TRANSMITTAL SHEET

<p>To: City of Mercer Island</p> <hr/> <p>Company: Department Services – Building & Planning</p> <hr/> <p>Address: 9611 SE 36 Street Mercer Island, WA 98040</p> <hr/>	<p>From: Erik Voris</p> <hr/> <p>Project: Project 2312-031</p> <hr/> <p>Date: 2/12/2024</p> <hr/> <p>Regarding: Correction Cycle#1</p> <hr/>
--	--

Planning Review Corrections received on 1/31/24 from Molly McGuire

3 AVERAGE BUILDING ELEVATION CALCULATION TABLE
 A0.2 SCALE: 1/16" = 1'-0"

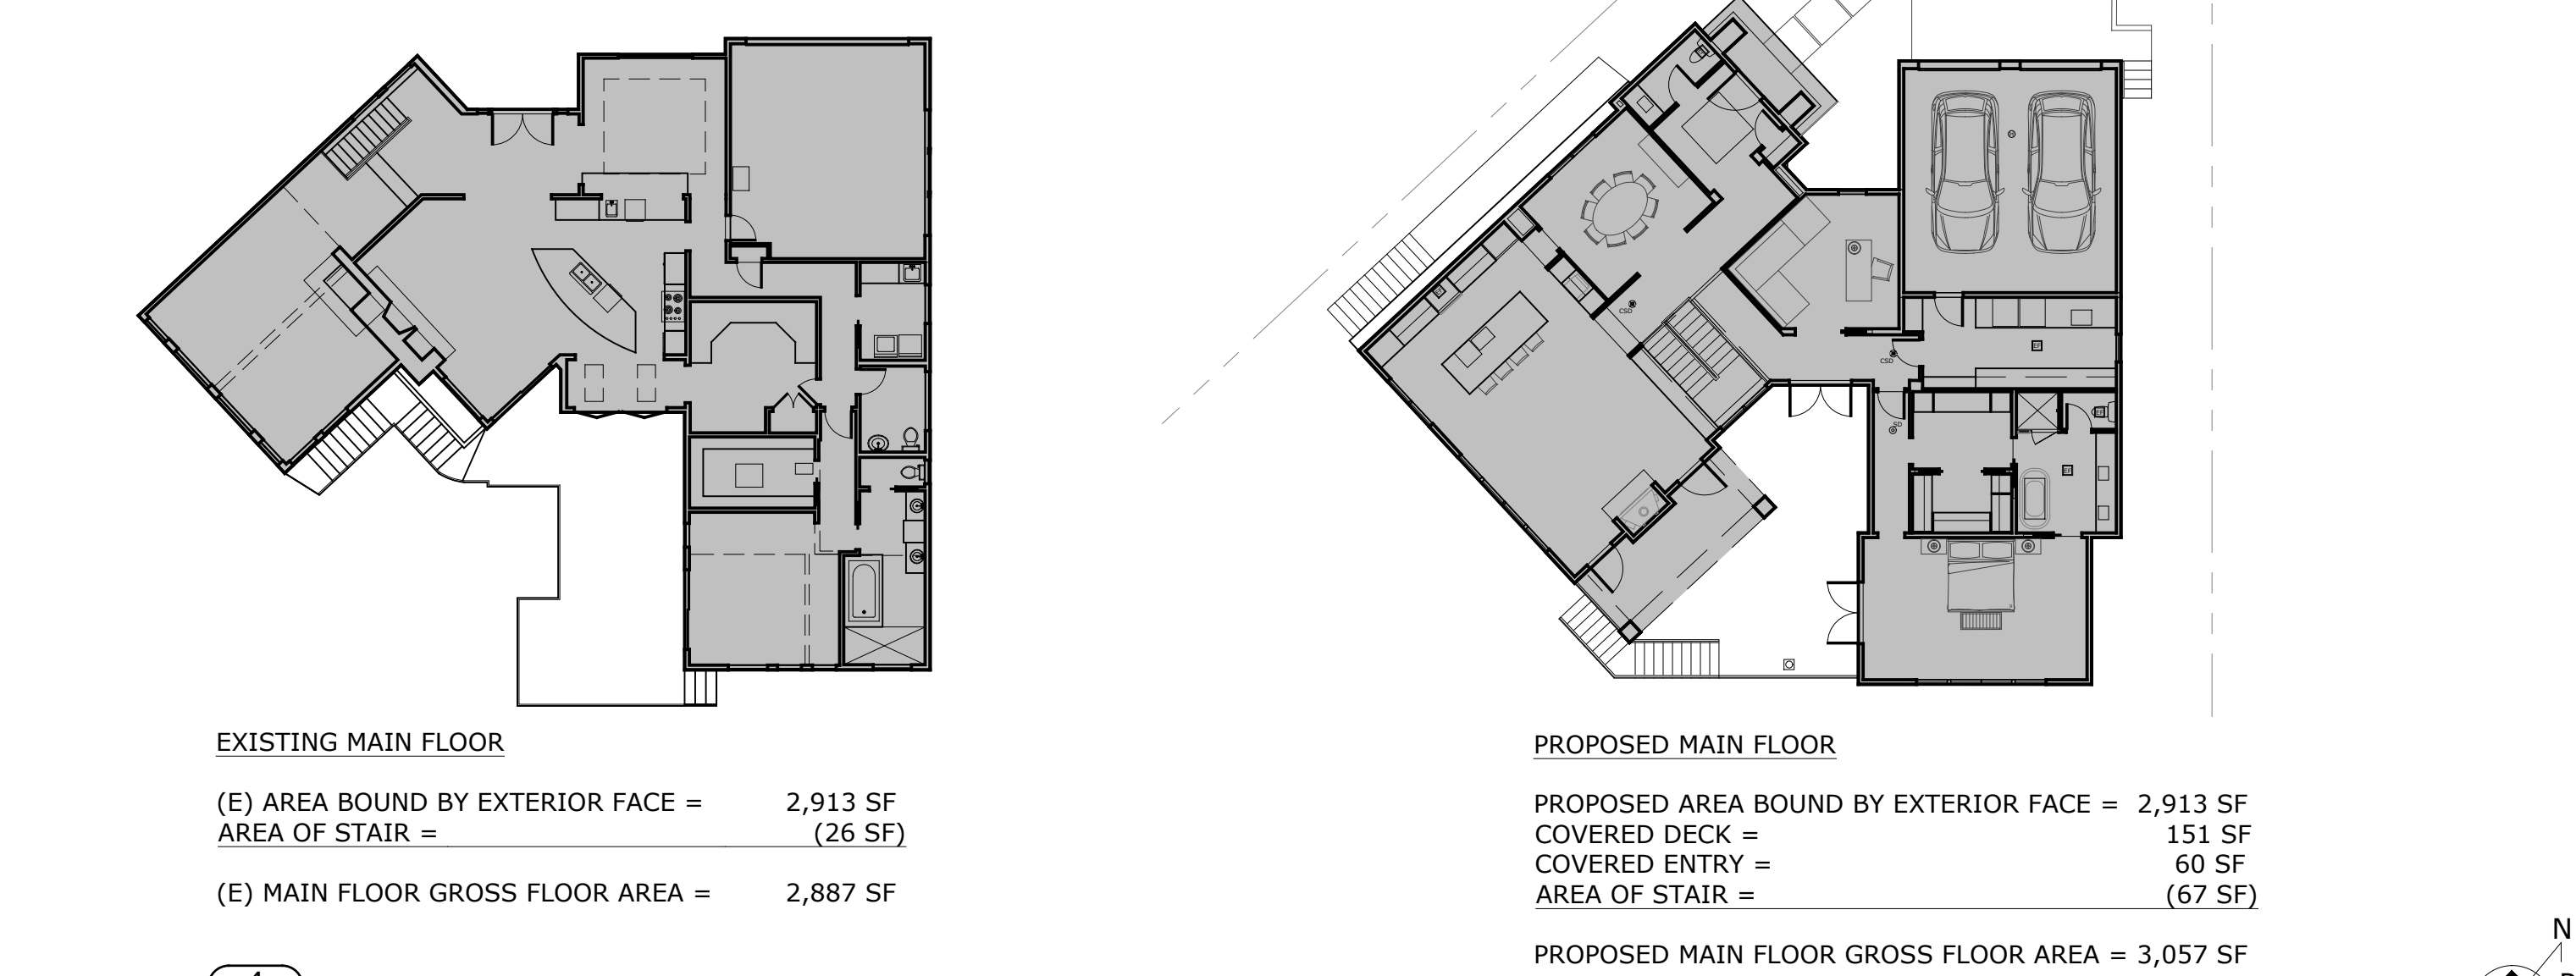
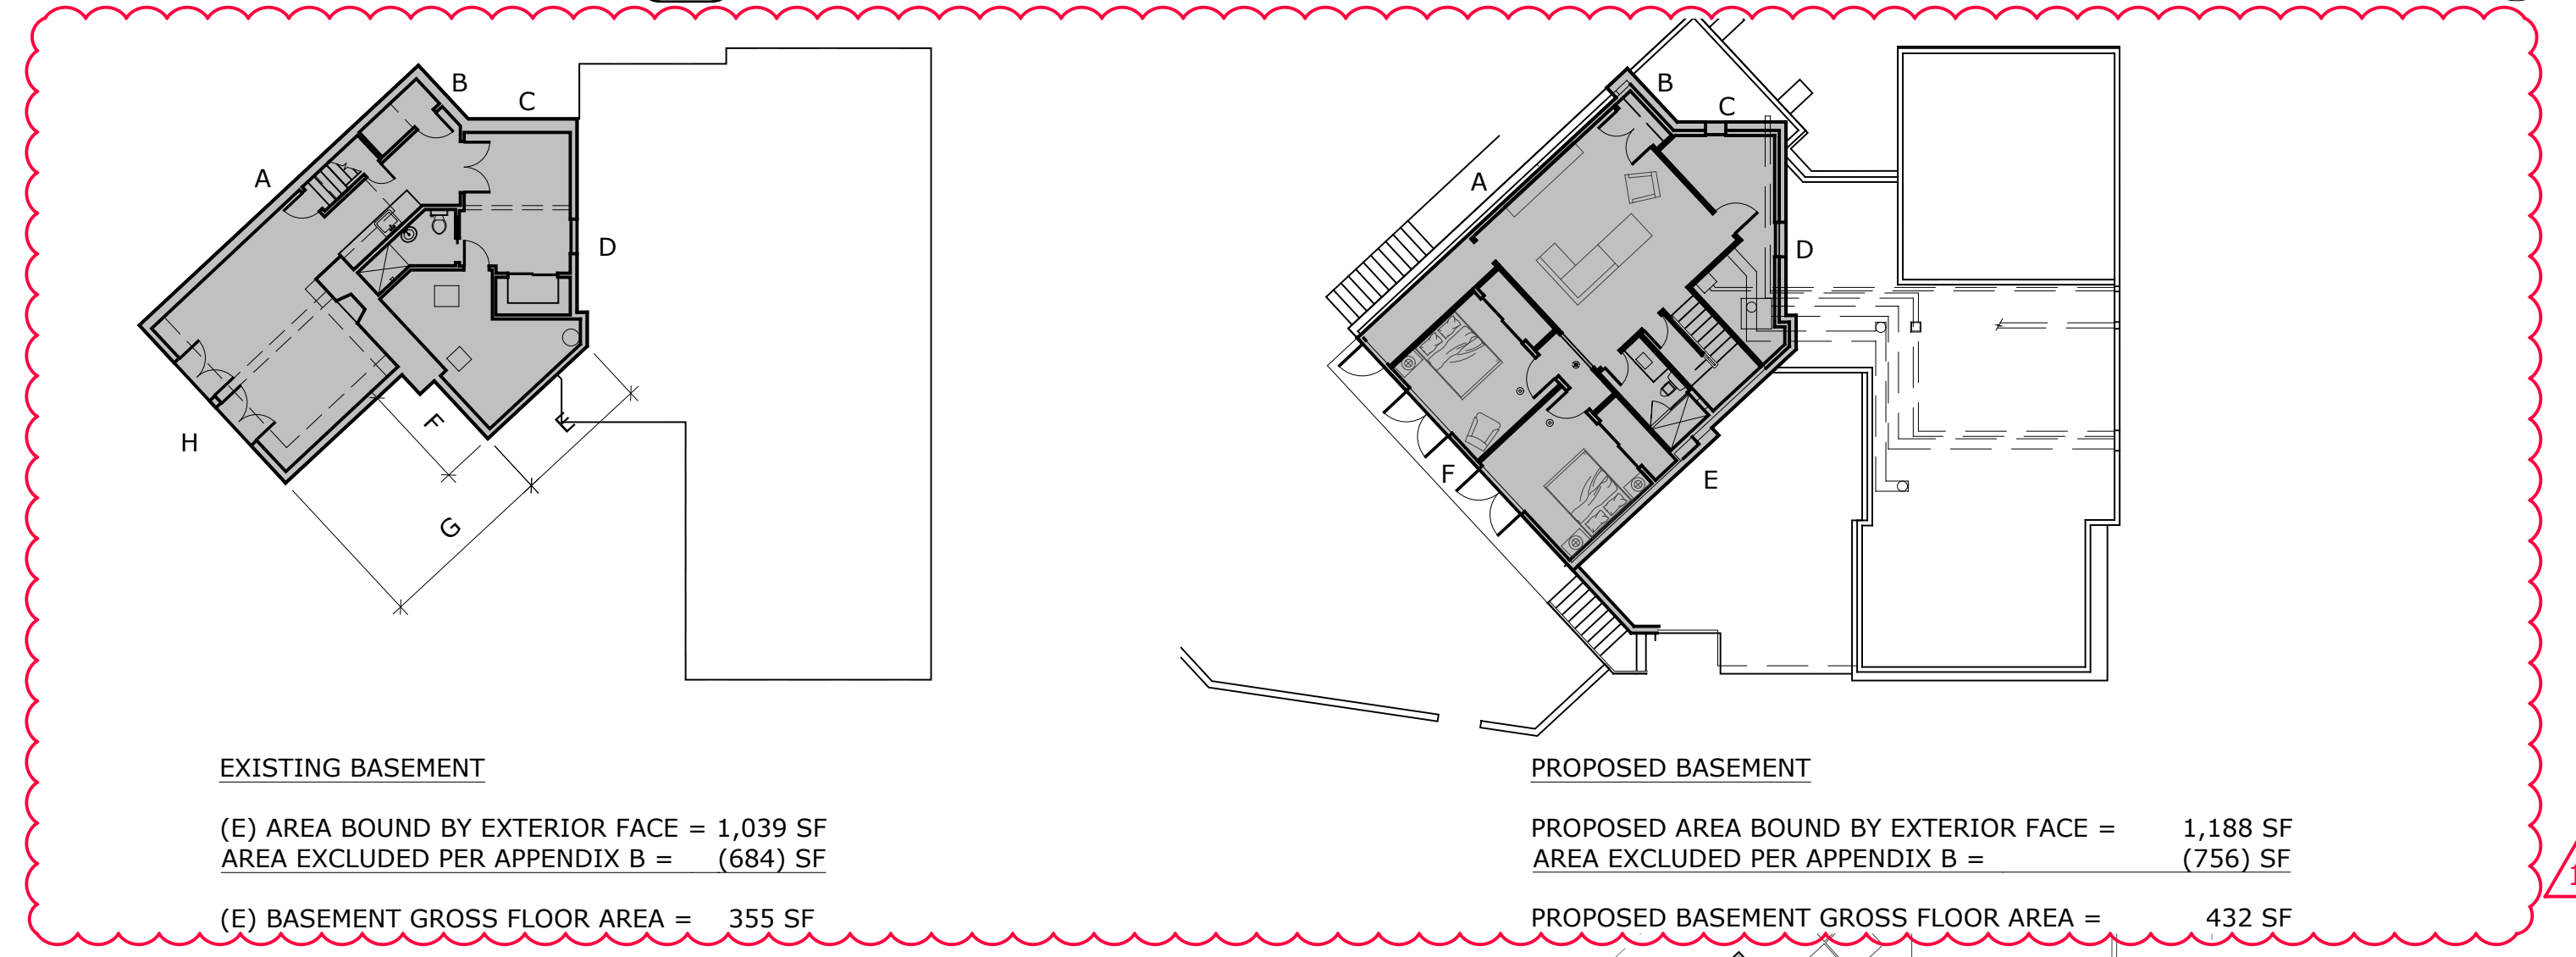
1. Sheet A0.1- Concurrent review form must be signed.
2. Sheet A0.1- Building permit application must be signed.
3. Sheet A0.2- Show average building elevation calculations in table format as shown in the site development worksheet (page 8).

4. Sheet A0.2- Indicate what lot coverage will be removed as part of the project.
5. Sheet A0.2- Indicate what hardscape will be removed as part of the project.

6. Sheet A0.2- Indicate what gross floor area will be removed as part of this project.
7. Sheet A0.2- Label wall segments to correspond with basement exclusion calculations.

- 3 - The average building elevation calculations have been added in chart format to sheet A0.2.**
- 4 - The lot coverage being removed is the existing roof area of the structure to be demolished. The existing basement foundation is not being removed and utilized in the new structure design.**

- 6 - The existing basement gross floor area calculation was revised. The existing and new gross floor areas are shown in the table on sheet A0.2.**
- 7 - The wall segments have been added to the proposed basement exclusion calculation diagram.**

A1.1

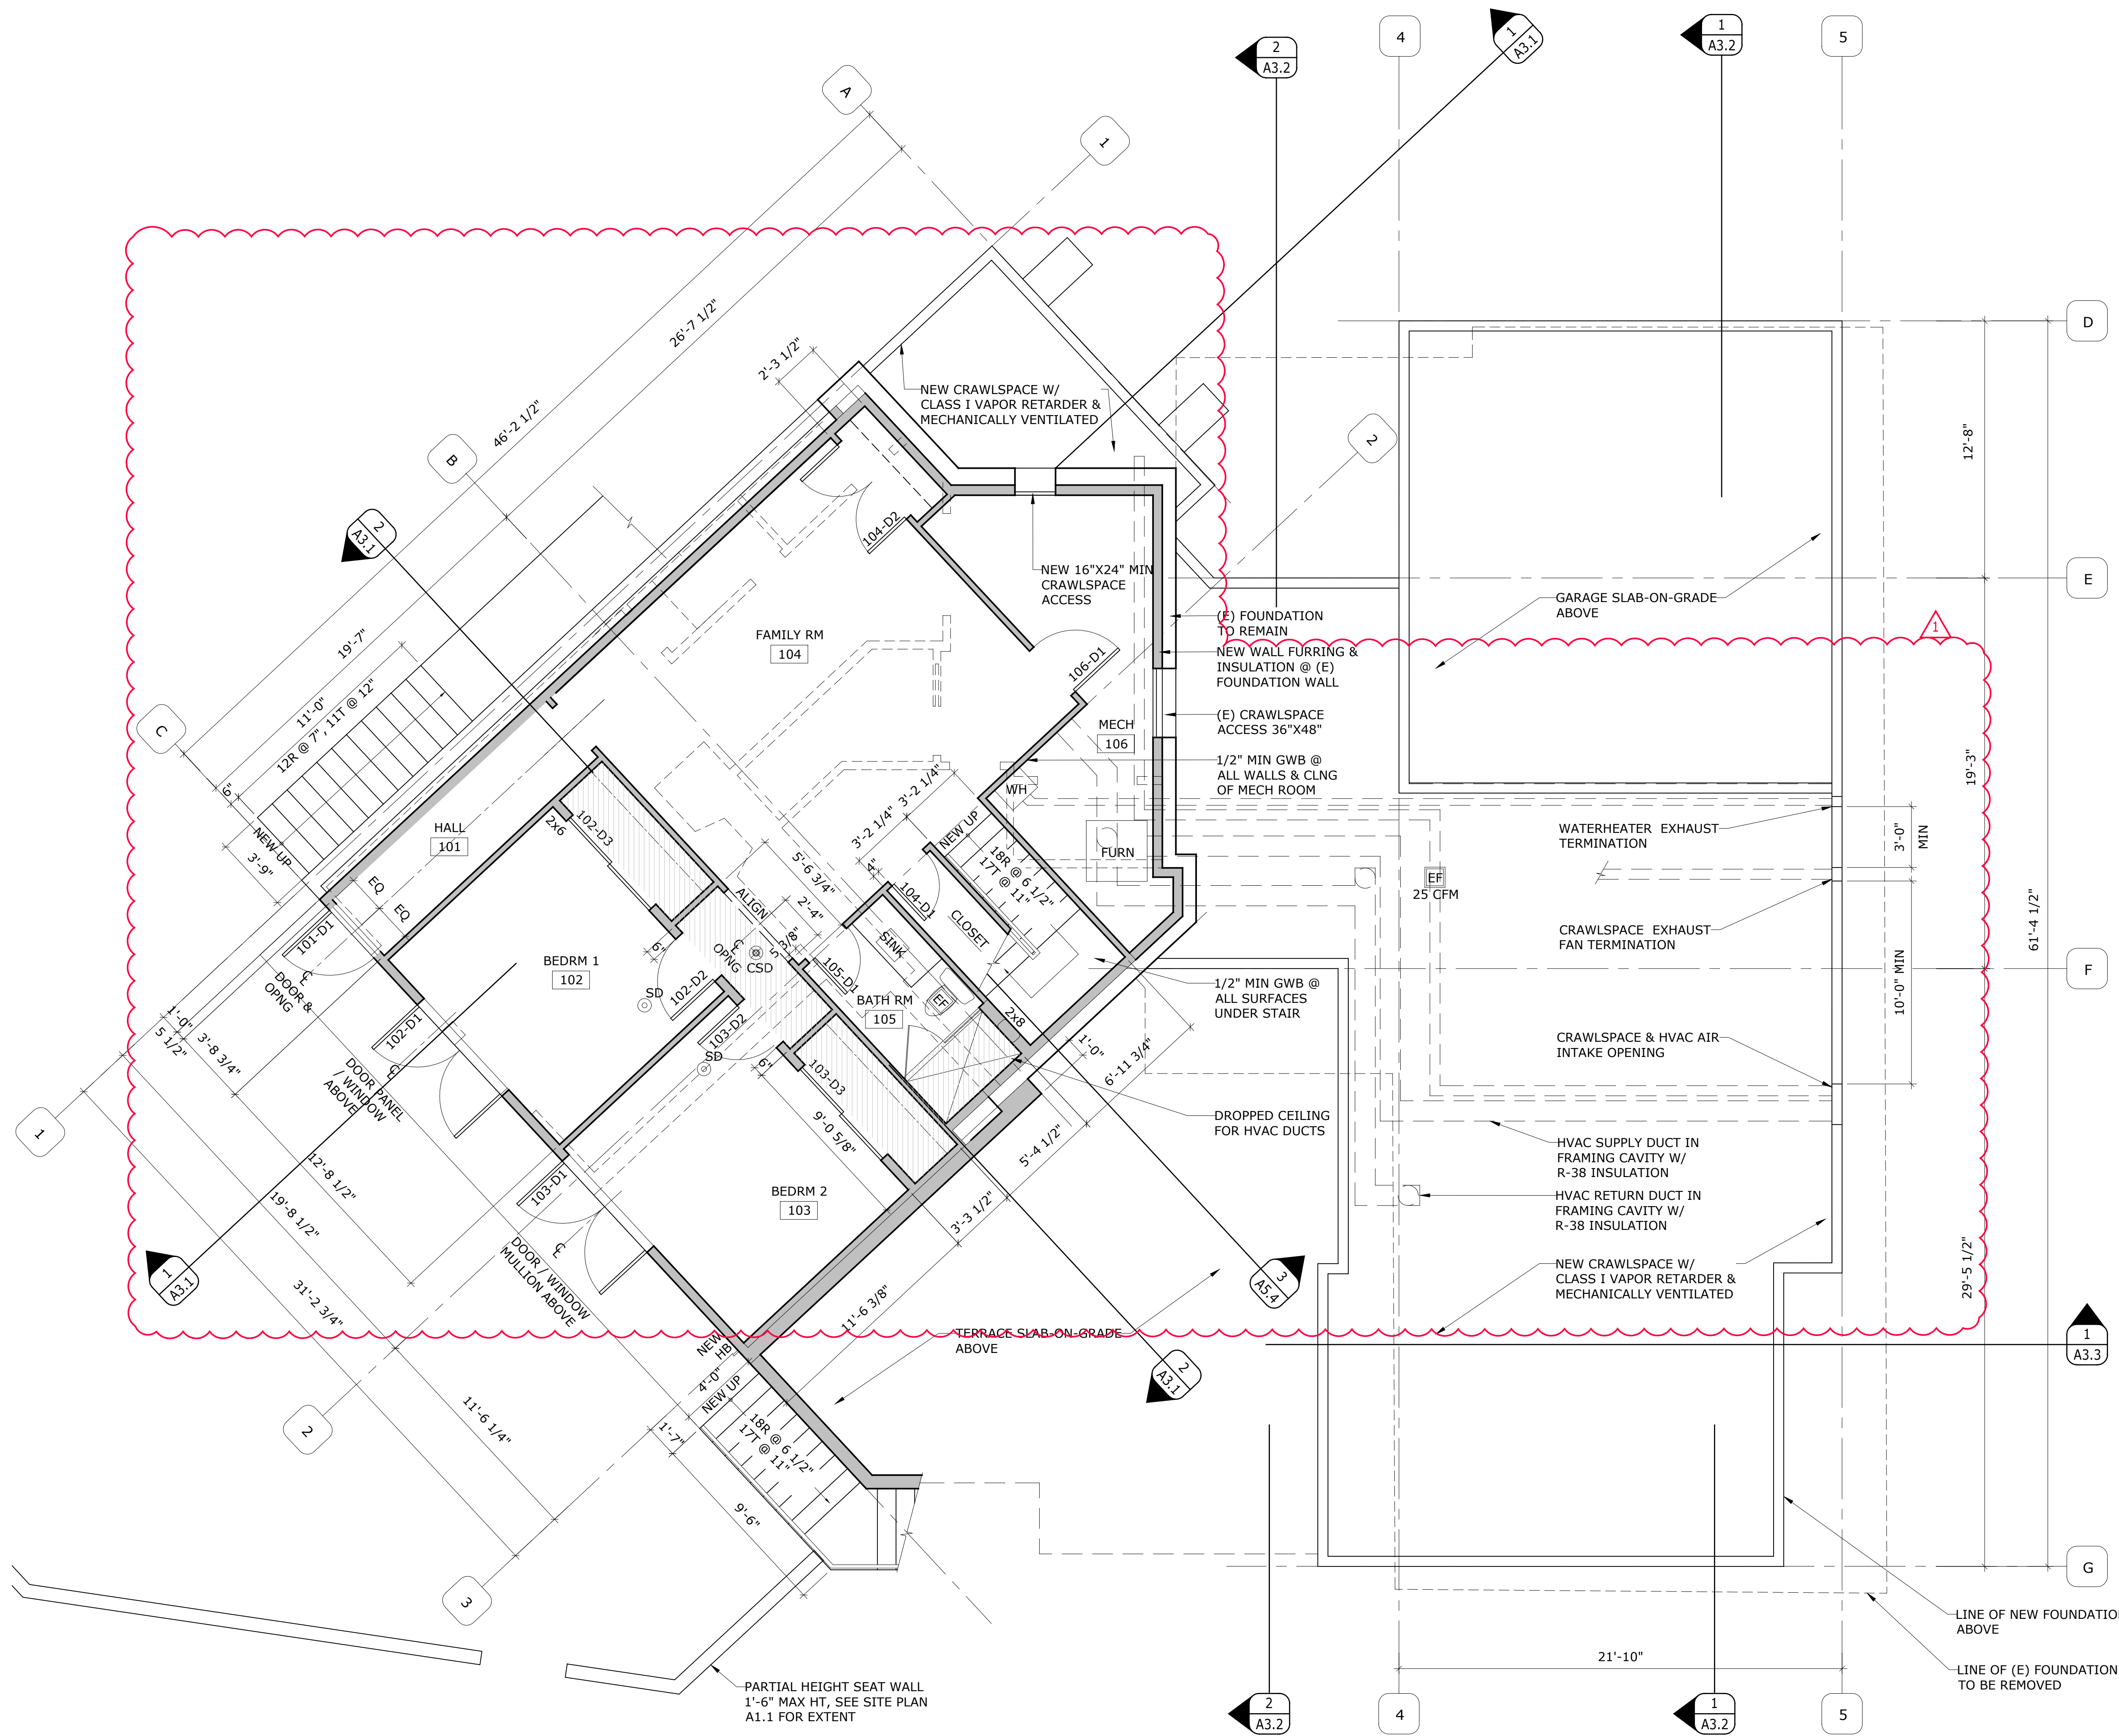
8. Sheet A1.1- Hardscape within required yard setbacks may not exceed 30 inches above existing or finished grade, whichever is lower. Add note for all hardscape within required yards per MICC 19.02.020(C)(3)(b).

- 5 - The hardscape being removed is shown on A1.1 as dashed. The areas are the existing driveway, entry paths, existing deck and stairs, and existing pool deck.**

- 8 - A clarifying note was added to the hardscape path and stair along the west side of the structure on sheet A1.1.**
- 9 - The Average Grade notes on the building elevations has been revised to Average Building Elevation.**
